**Our Ref: A/02760**

**11th November 2025**

**Rear of 23 to 43 Moor Lane, Gomersal, Cleckheaton - (KIRK) Reserved matters application pursuant to outline permission 2023/92079 for erection of residential development of 10 dwellings, demolition of existing extension at 27 Moor Lane, widening of existing access and realignment of boundary walls**

Scale	Drawn	Checked	Approved
1:250	MA	ZS	ZS
Original Size	Date	Date	Date
A1	26/09/2025	26/09/2025	26/09/2025
Drawing Number	Author	Checked	Approved
PV2511-APP-92-XX-DR-C-2500			P04

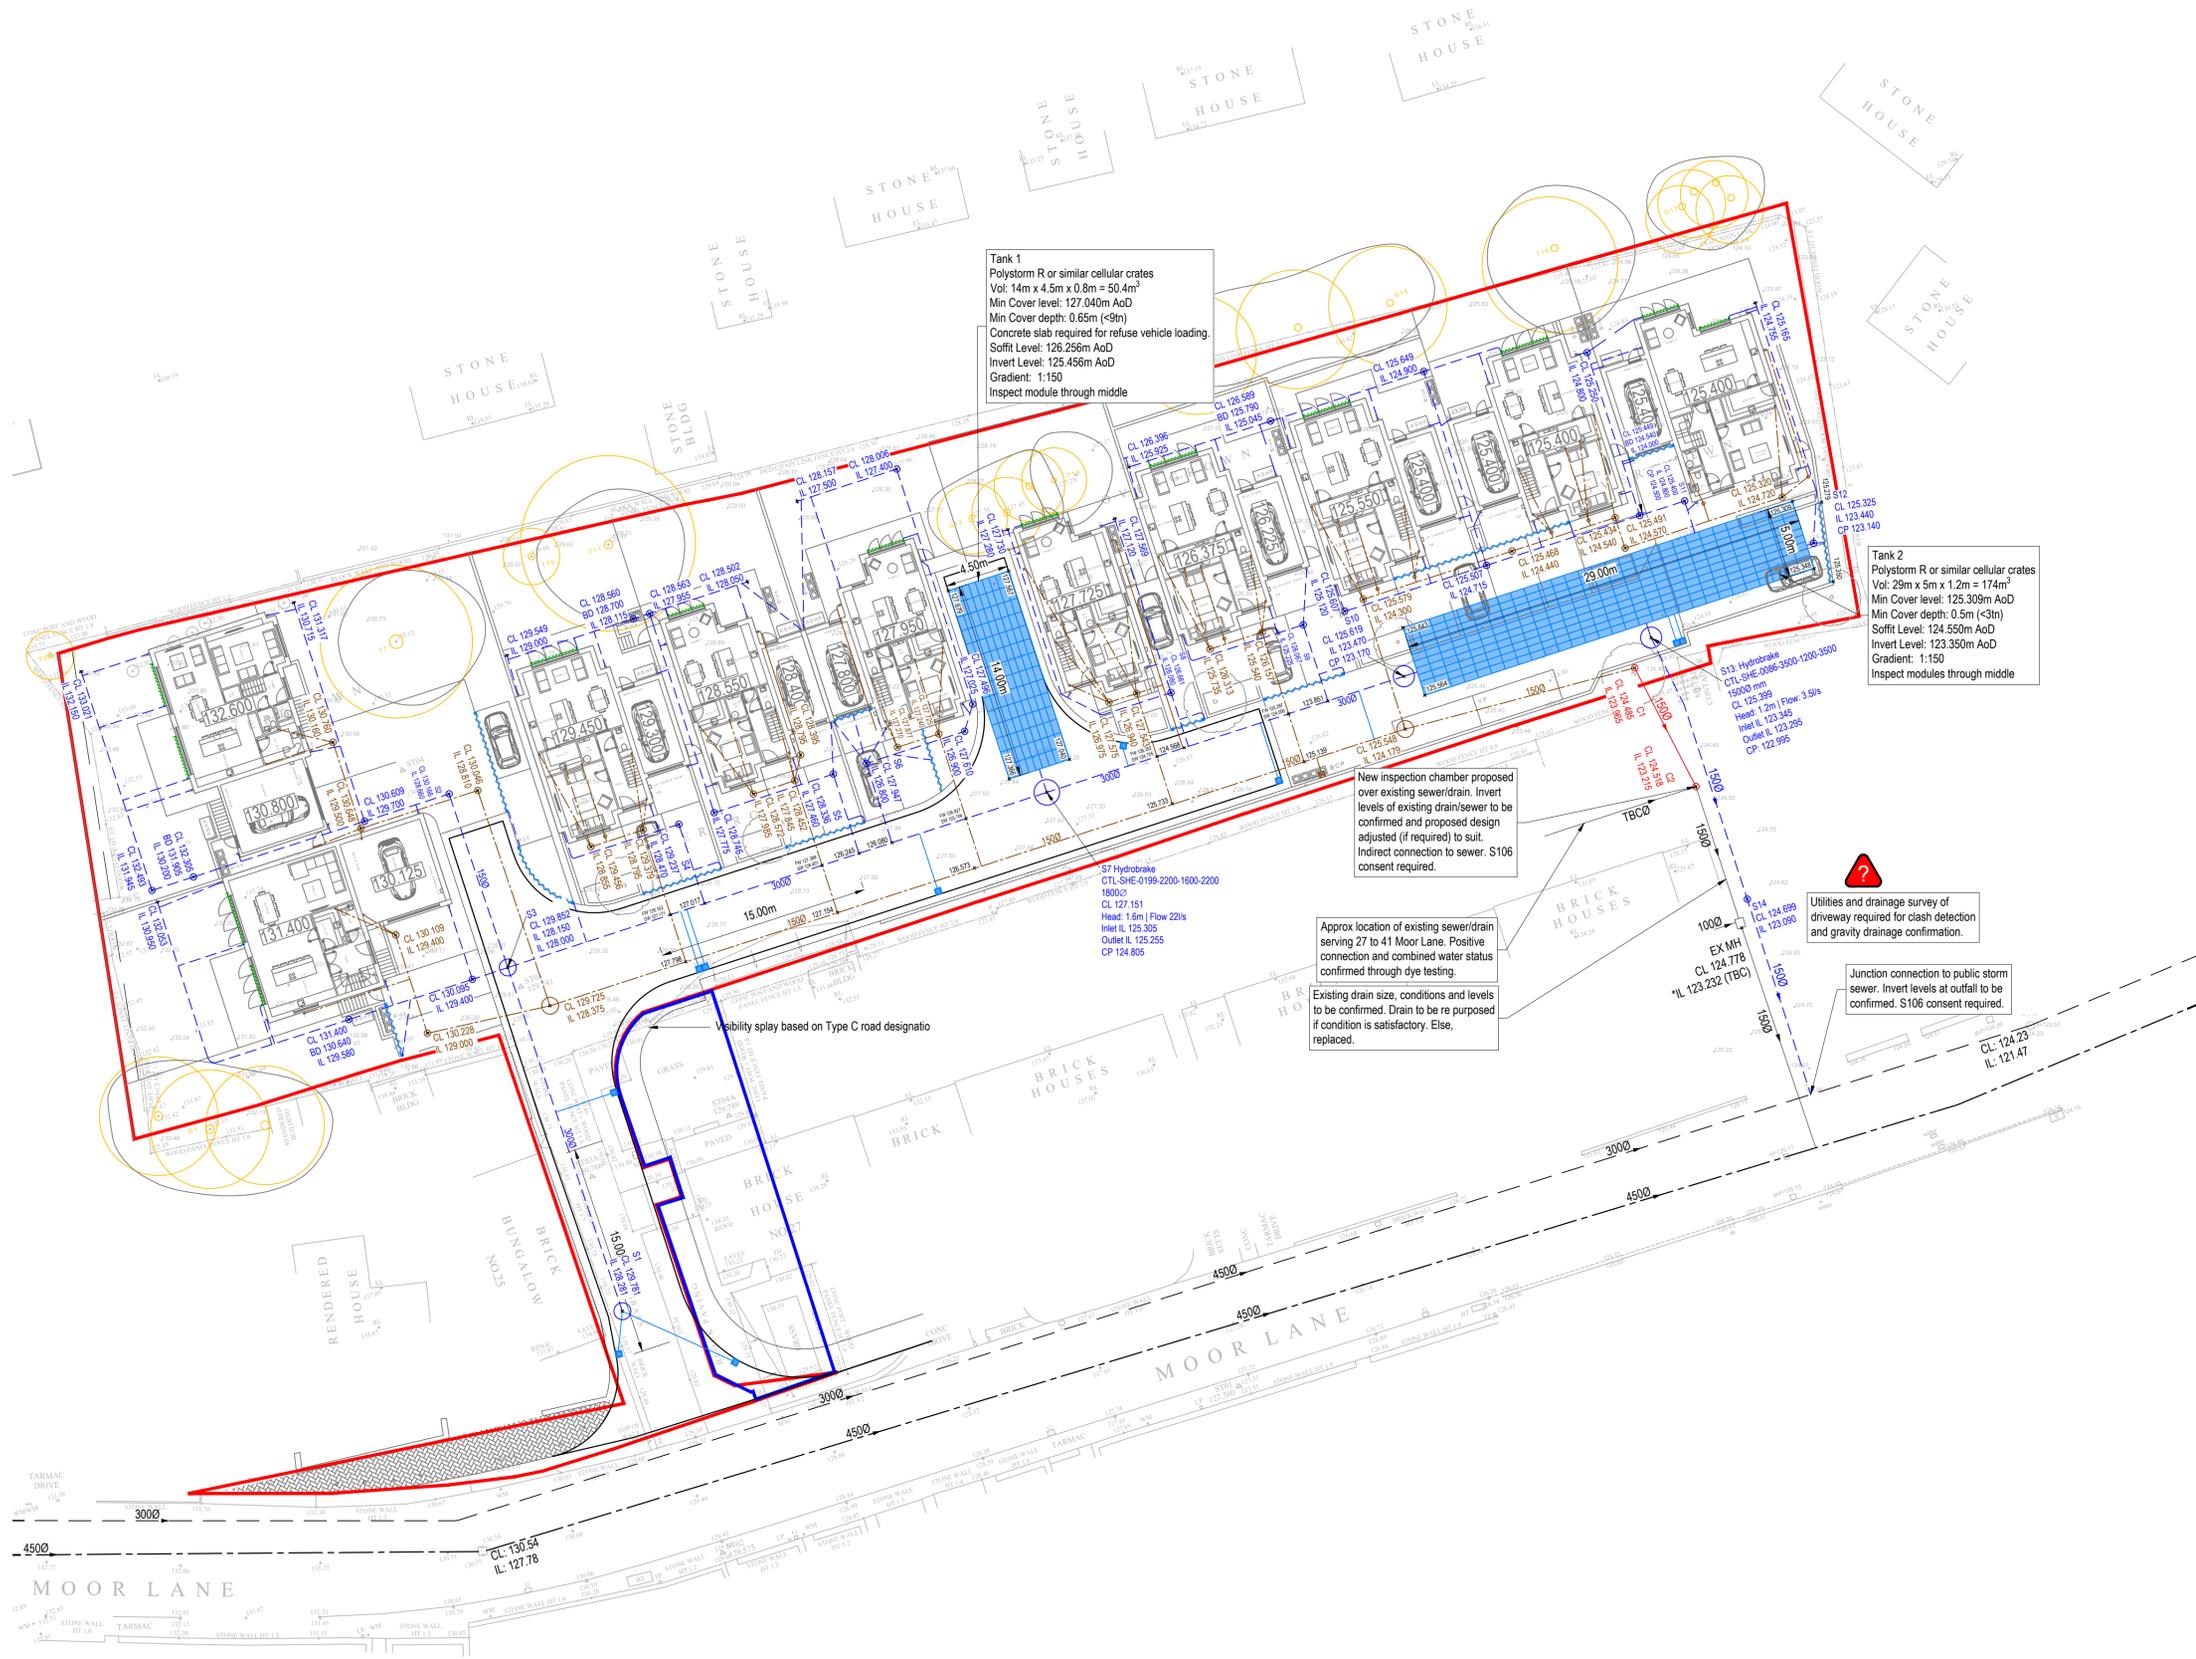
**Yorkshire Water object to the approval of the reserved matters application in so far as those matters may be affected by alterations to the drainage arrangements.**

The drainage details submitted on drawing PV2511-APP-92-XX-DR-C-2500 (revision P01) dated 26/09/2025 that has been prepared by Align Property Partners are unacceptable. The following points should be addressed:

- 1) The submitted drawing appears to show both foul and surface water discharging to the public foul sewer in Moor Lane
- 2) Within Moor Lane there are both foul and surface water public sewers available for use. It appears these separate systems exist, manholes are present at either end of Moor Lane and further evidence is required if the developer suggest the surface water sewer does not exist.
- 3) Evidence should be submitted to show that other (than discharge to public sewer) means of surface water disposal have been considered and why they have been discounted
- 4) The submitted drawing should show foul and surface water drainage proposals both on and off site and discharges to the separate sewer systems
- 5) The rate of discharge of surface water should not exceed 3.5 litres/second.
